# Road Safety Audit Report

**Incorporating**  
**Stage 1/2 Completion of Detail Design;**  
Design Organisation Response to items raised.

## **Proposed Works to existing Public Footpaths through Meadow Gardens, North End Road Yapton**

| <b>Job no</b>            | RSA-20-193                                    | <b>Issue no</b>    | 3  | <b>Date</b>        | March 2021 |

Drawing Title
Sections through public right of way footpath 357

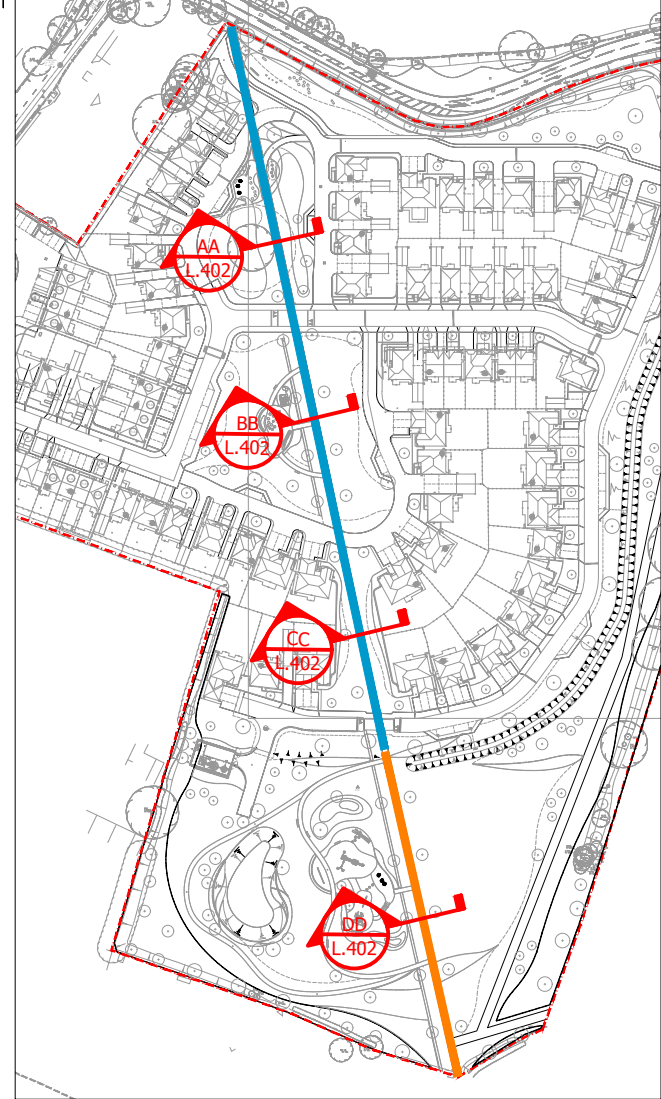
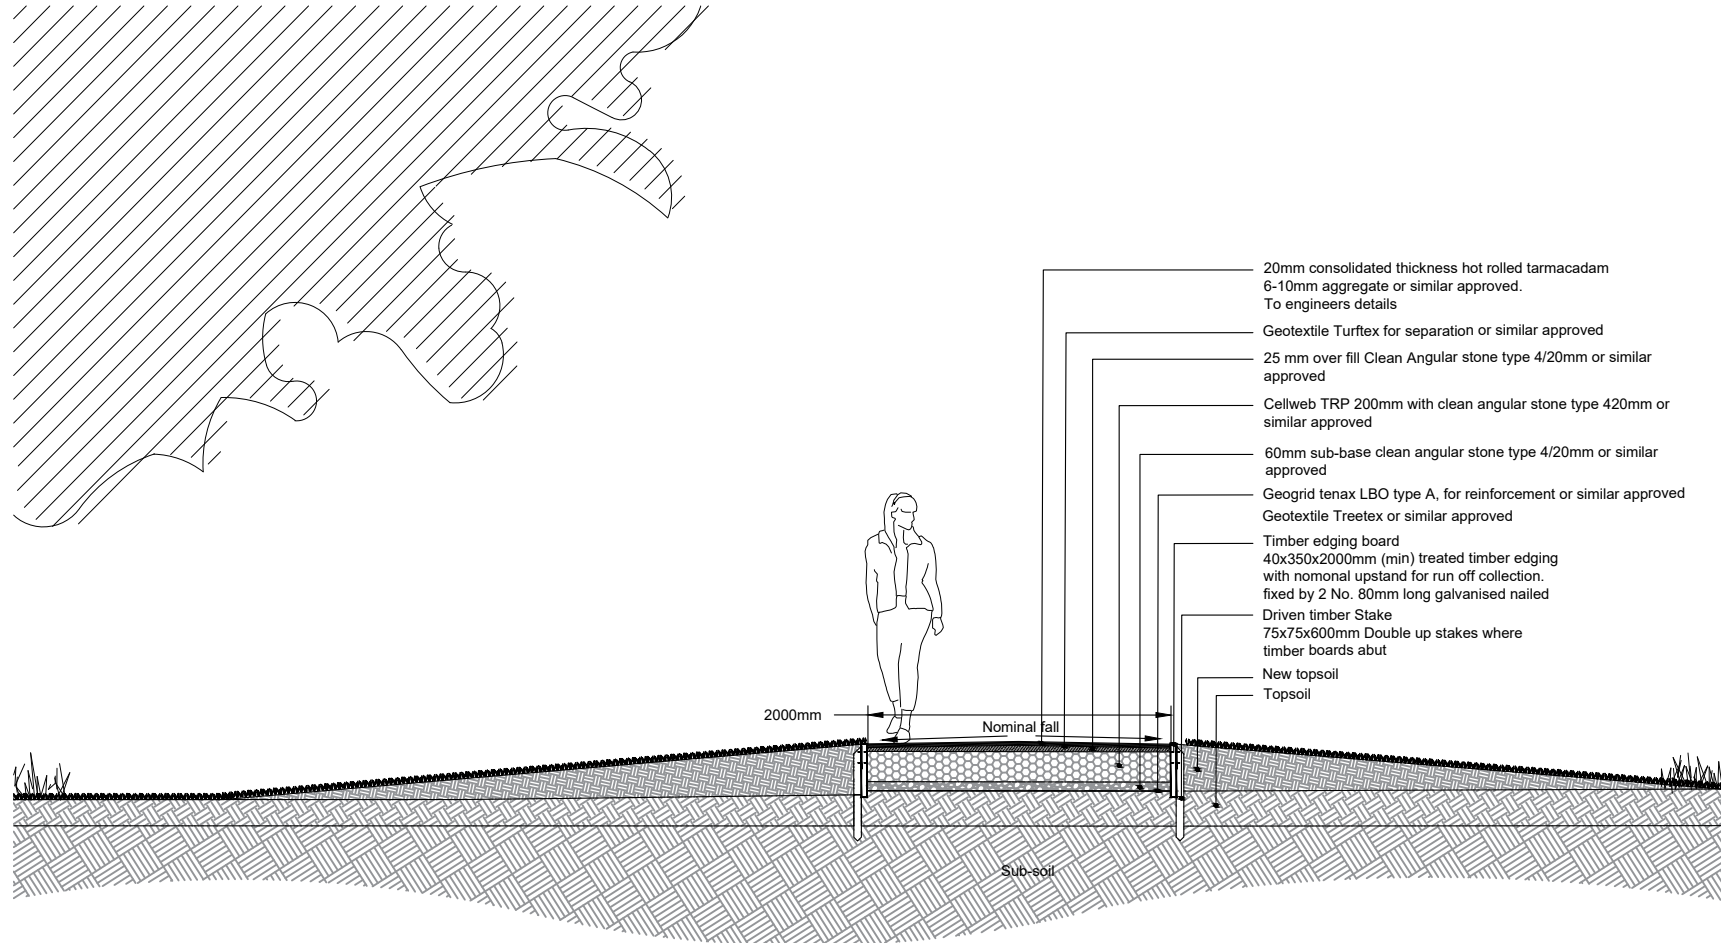
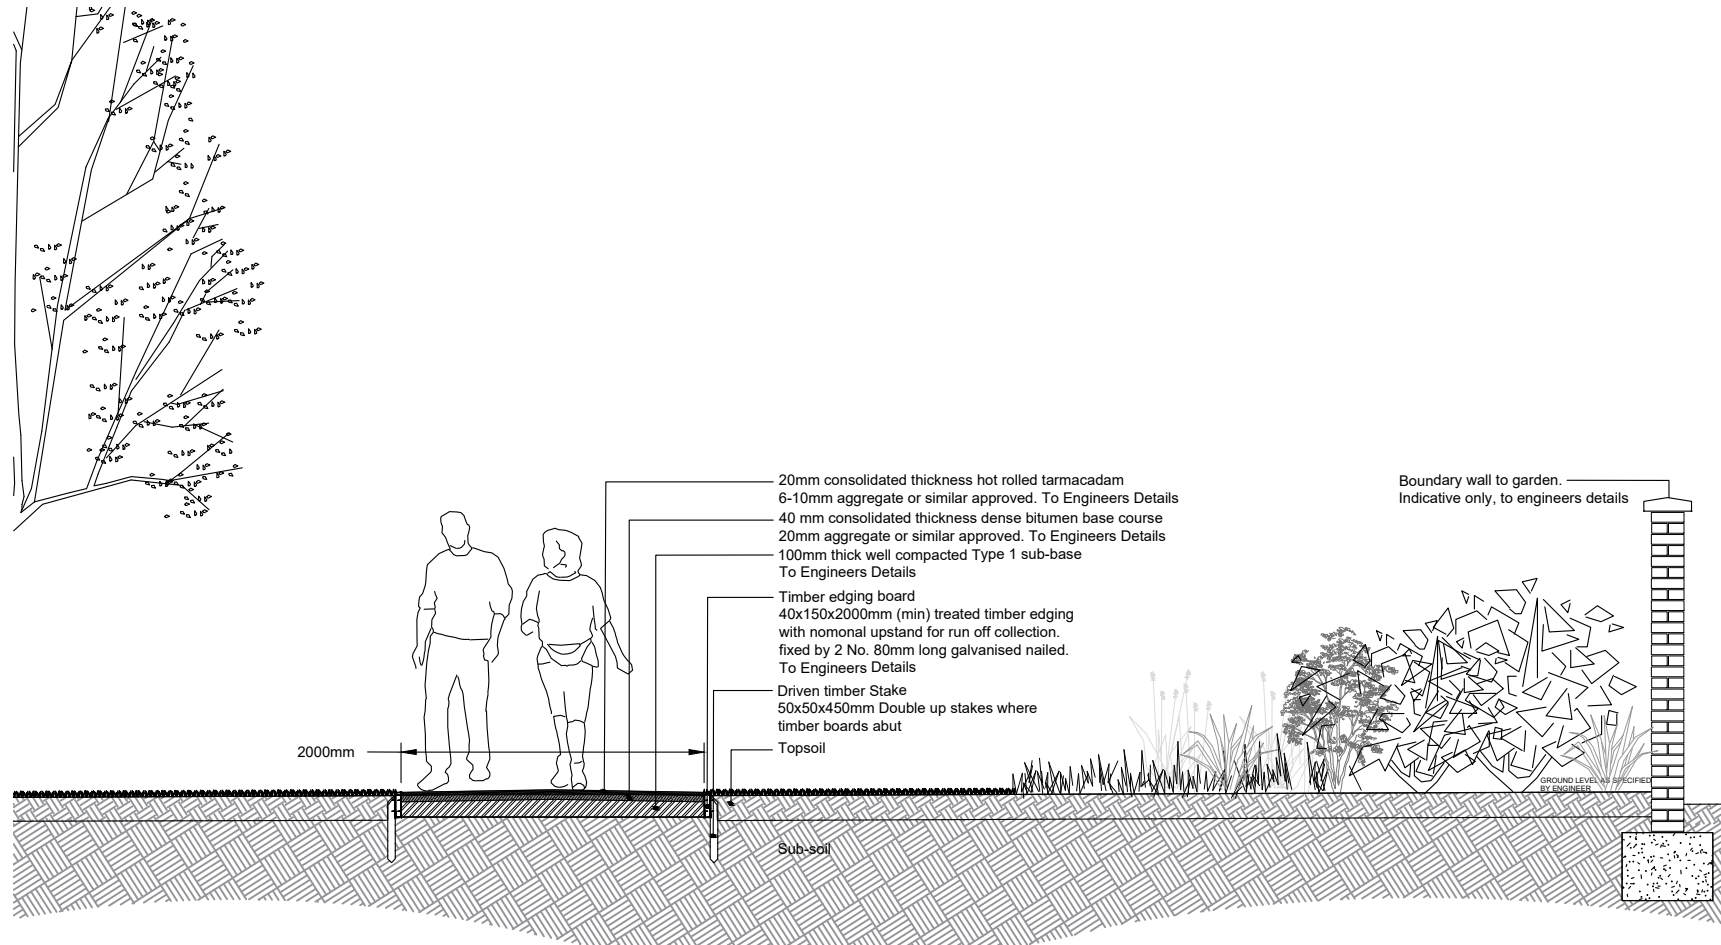
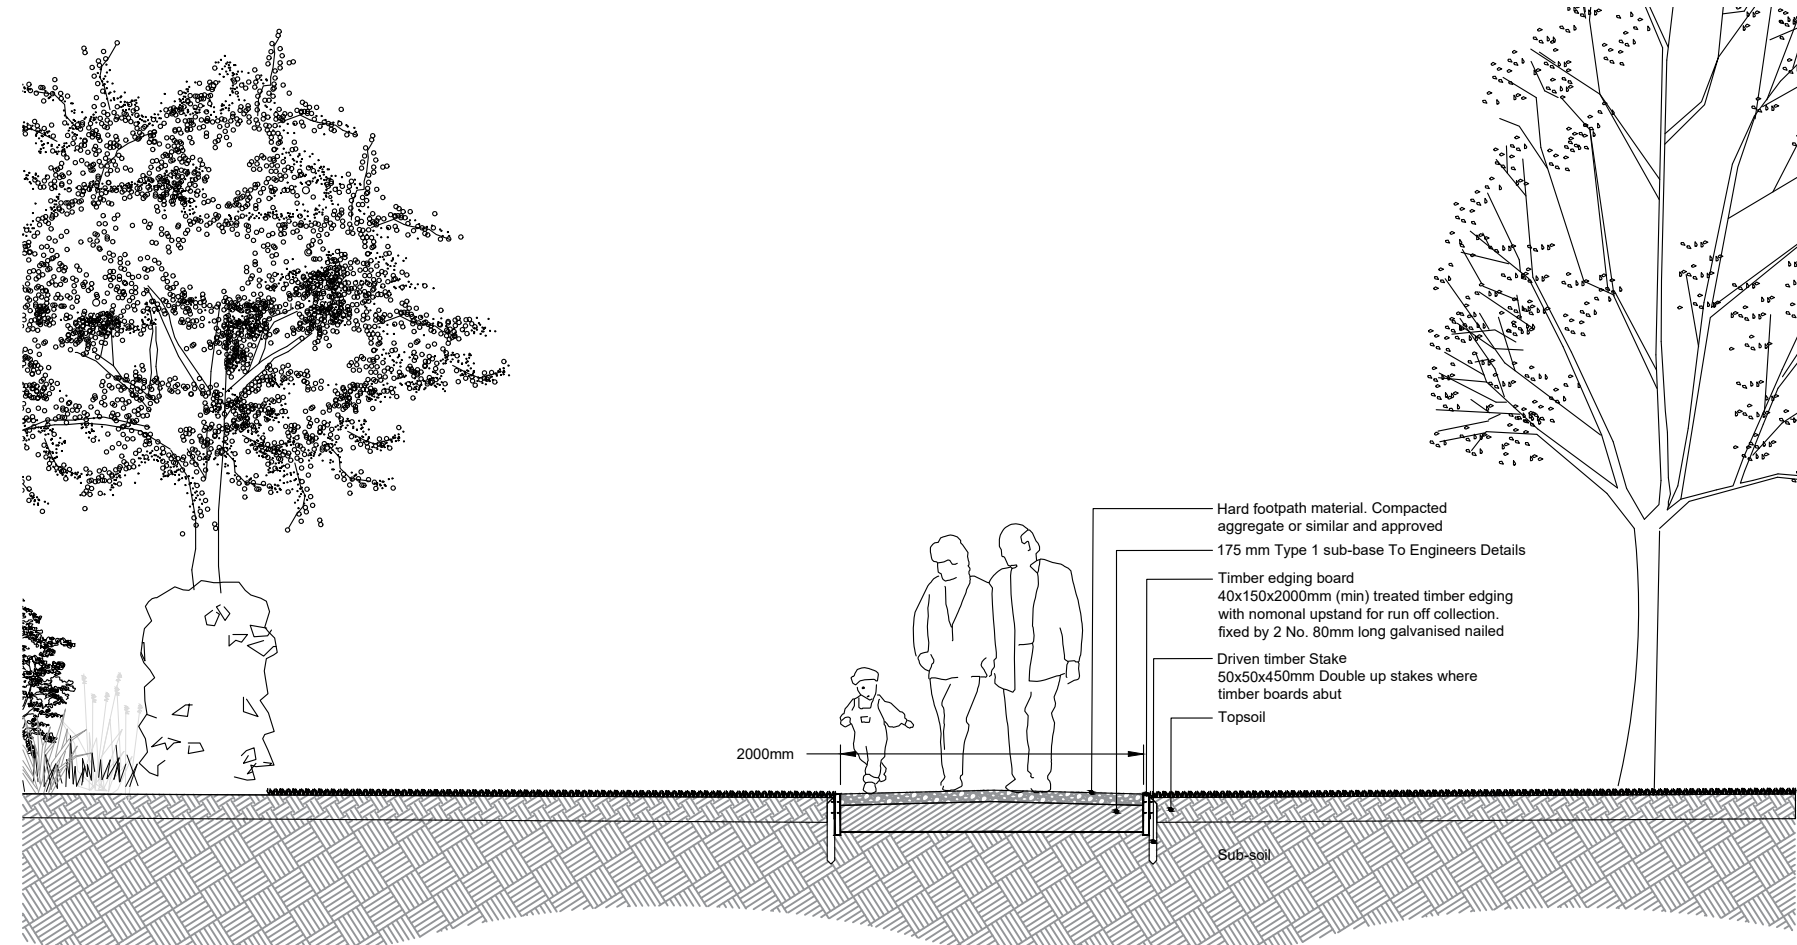
| <p>Footpath 357 forms a public right of way that currently passes between the southeast and northwest extents of a field meeting footpaths 358 and 359 to southeast and Ford Lane to the northwest. The field is set above the level of the Ford Lane carriageway with access gained via a set of 6 uneven concrete slab steps with a wooden handrail, up the grass embankment. The Audit Brief that has been supplied to provide sufficient information to undertake this Stage 1/2 Road Safety Audit, states that the connections between the site and existing rights of way which are outside the redline boundary, are outside the scope of the Audit and that the current proposals are to provide footpaths within the application site. However, it is understood that there are aspirations to upgrade footpath 357 to a footway cycleway. Whilst the existing connection between the footpath and Ford Lane allows pedestrian to walk up steps that are currently substandard and result in a pedestrian stepping straight onto the carriageway, the use of the connection by cyclists would result in the requirement for a bicycle to be transported up / down steps and could lead to cyclist falling and a personal injury or falling into the Ford Lane carriageway into the path of a vehicle resulting in a vehicle cyclist collision.</p> |                                                                                         |
| <p>It is recommended that the northern most section of footpath 357 is reduced to 2 metres and measures are provided to deter use by cyclists with landscaping / planting provided either side of the staggered barriers to ensure that cyclists cannot bypass the measures.</p>                                                                                                                                                                                                                                                                                                                                                                                                                                                                                                                                                                                                                                                                                                                                                                                                                                                                                                                                                                                                                                                                            |                                                                                         |

Accepted – the width of the footway has been narrowed to 2m and landscaping features have been identified on either side of the path/barrier to prevent by-passing of the infrastructure. The revised design is presented in drawing ITB14679-GA-002 Rev C.
